Rezoning Transportation Analysis

Petition Number: 2022-200

Reviewer: Travis Miller
Travis.Miller@charlottenc.gov
980-221-5778

Date	Description
4-27-23	First Review (TM)
05-24-23	Second Review (TM)
07-26-23	Third Review (TM)

SCHEMATIC SITE PLAN

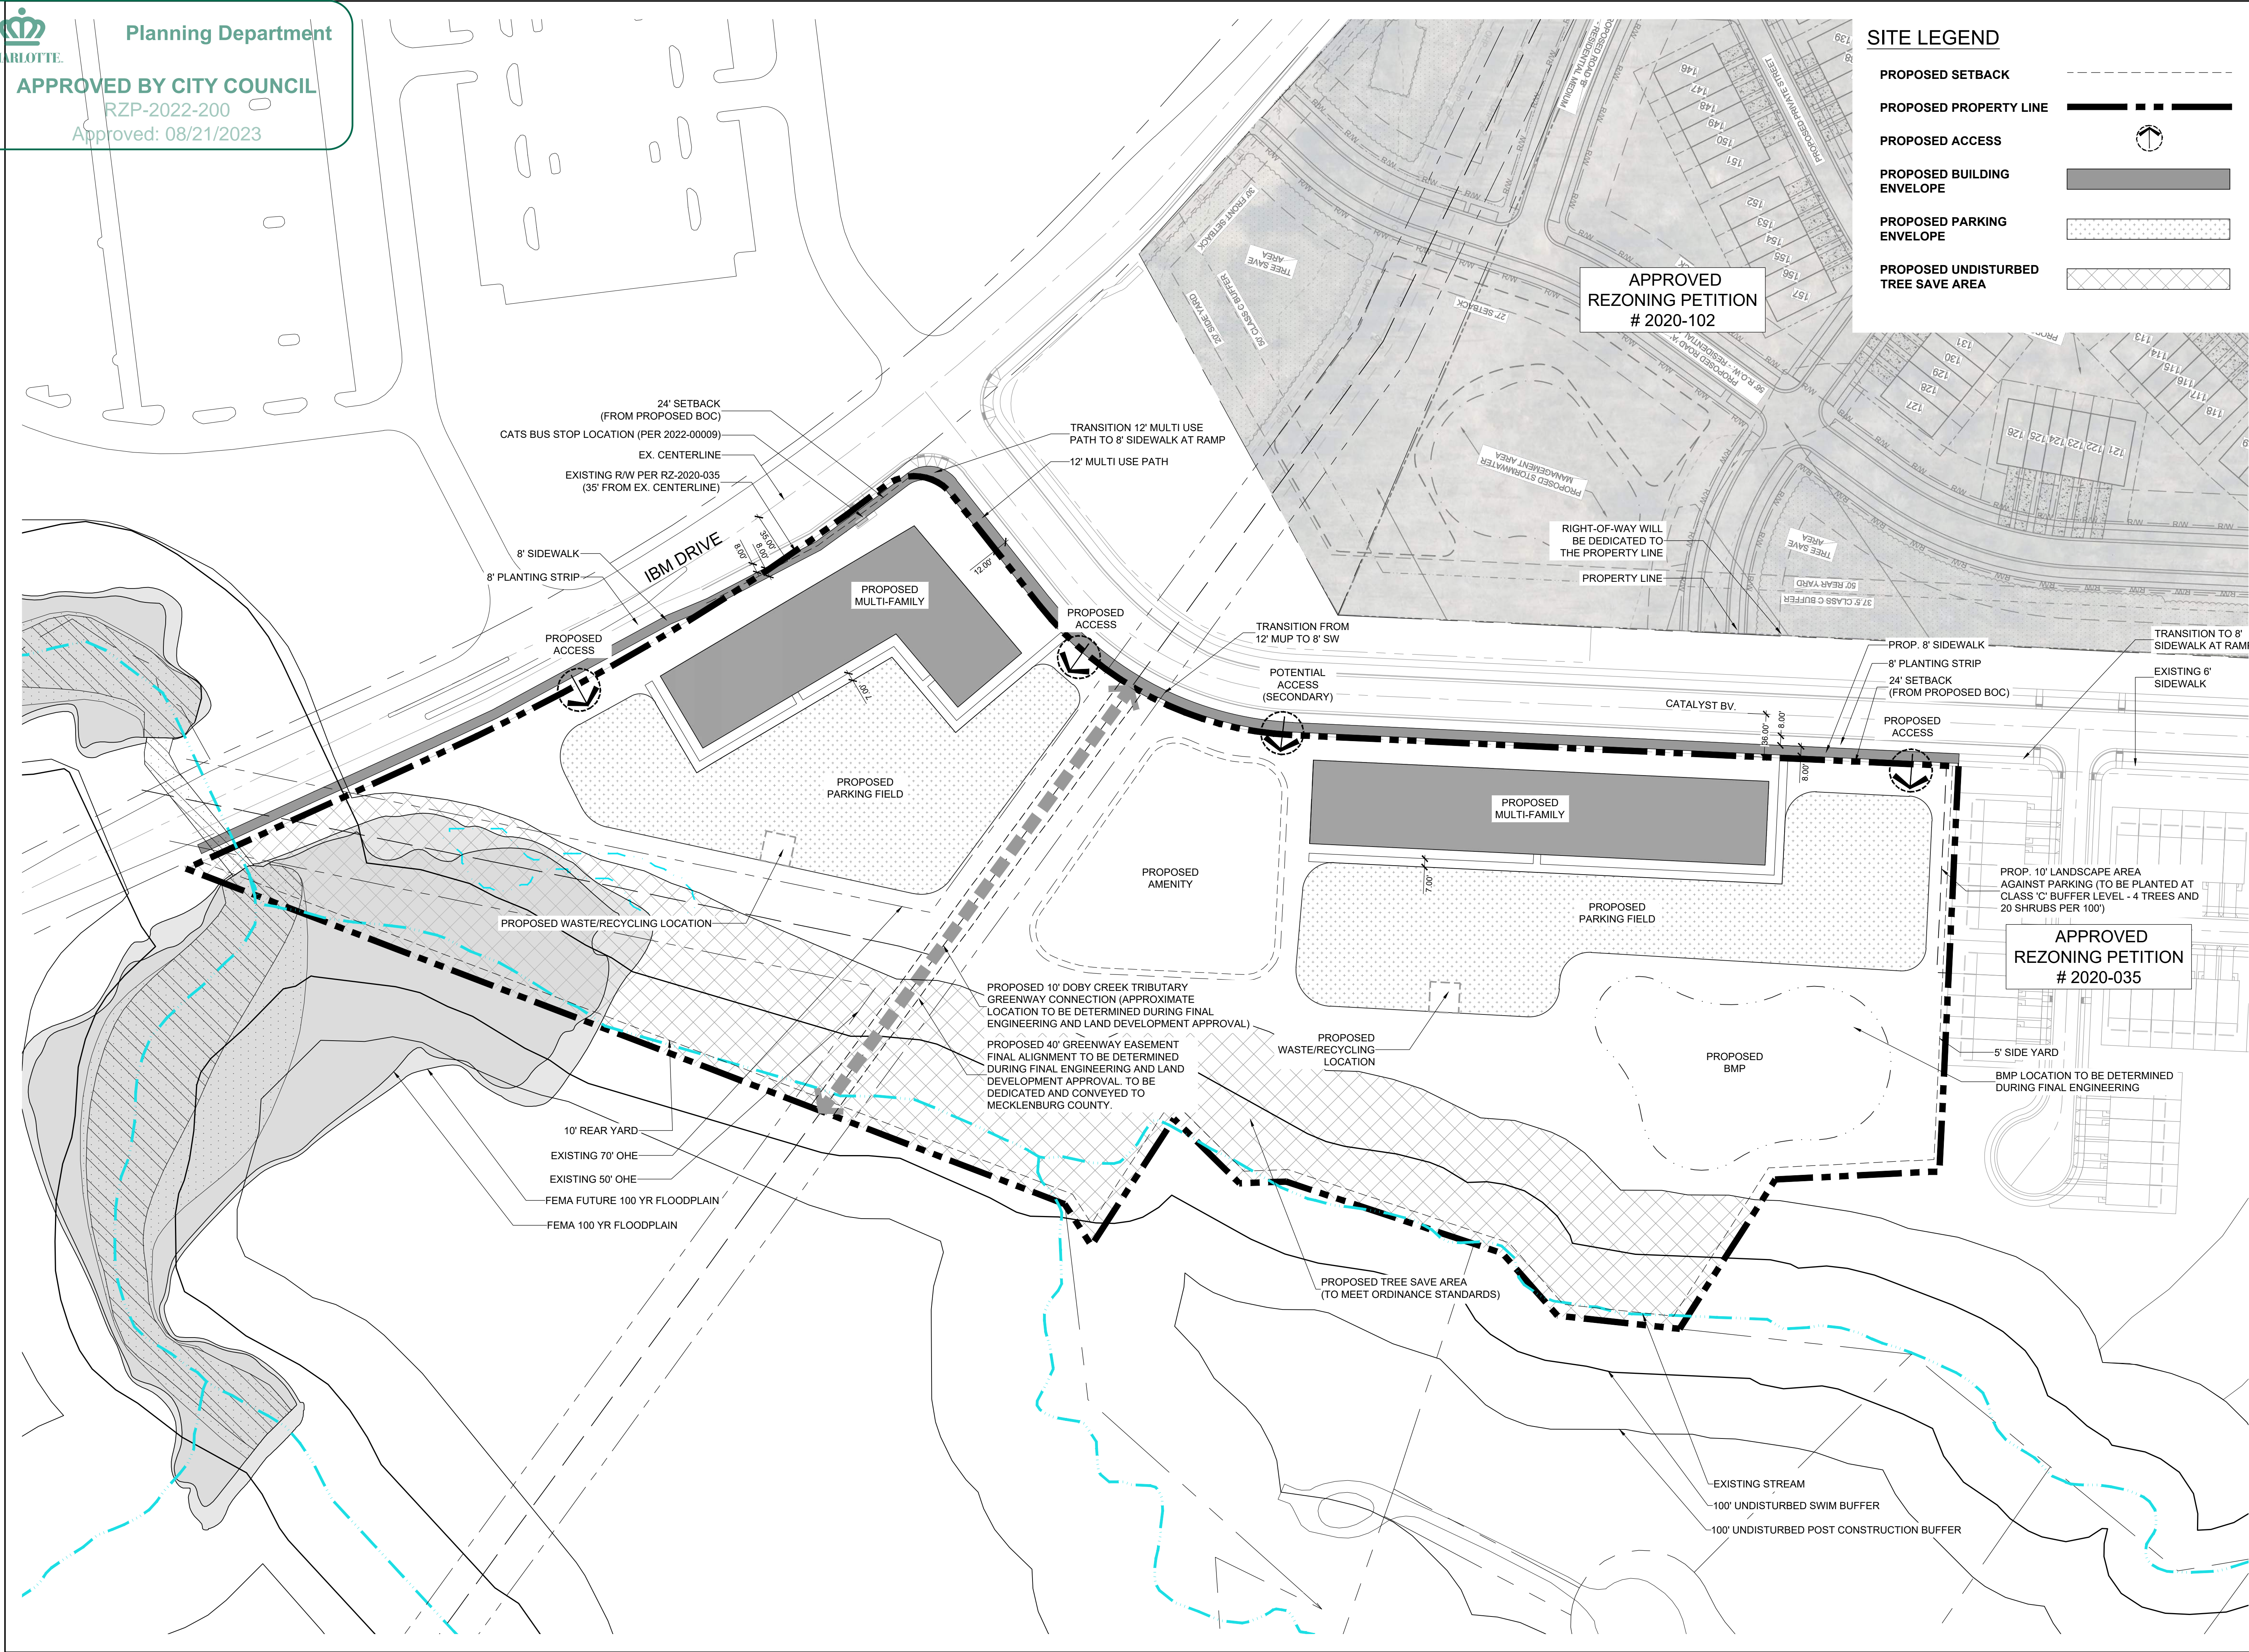
- a. ~~IBM Drive:~~ Location of curb and gutter to be moved to 10 feet from roadway centerline to accommodate the Charlotte Streets Map with a roadway typical section of 2+ Avenue with a Shared Use Path.
- b. ~~Catalyst Boulevard:~~ The future location of the curb and gutter is being constructed in accordance with detail U-07, Local Collector typical section from the Charlotte Land Development Standards Manual.

~~Label and dimension the curb and gutter from the centerline for each road on the site plan.~~

3. ~~Revise site plan and conditional note(s) to commit to dedicate 35-foot of right-of-way from the road centerline of IBM Drive. The site plan shall label and dimension the right-of-way from the road centerline.~~

4. ~~The proposed dwelling units exceeds 12 per acre. Per Chapter 20 Subdivision ordinance, revise site plan and conditional note(s) to commit to construct an 8-foot planting strip, and 8-foot sidewalk along Catalyst Boulevard. The wider sidewalk also meets the Charlotte WALKS Policy.~~

5. ~~Revise site plan and conditional note(s) to commit to construct bicycle facilities by installing a 12-foot multi-use path to meet the Council-adopted Charlotte BIKES Policy on IBM Drive. Multi-use paths maintained by the City shall meet ADA/PROWAG requirements.~~

7. ~~Revise site plan and conditional note(s) to commit to installing a 2 (inbound and outbound) CATS bus stops on IBM drive.~~
8. **Outstanding Comment from 04-27-23:** ~~Revise site plan and conditional note(s) to commit to revising southern access location to align with the adjacent development access shown from rezoning 2020-102.~~ **Clarifying Comment 05-24-23** Show access as relocated to align or remove from plan.
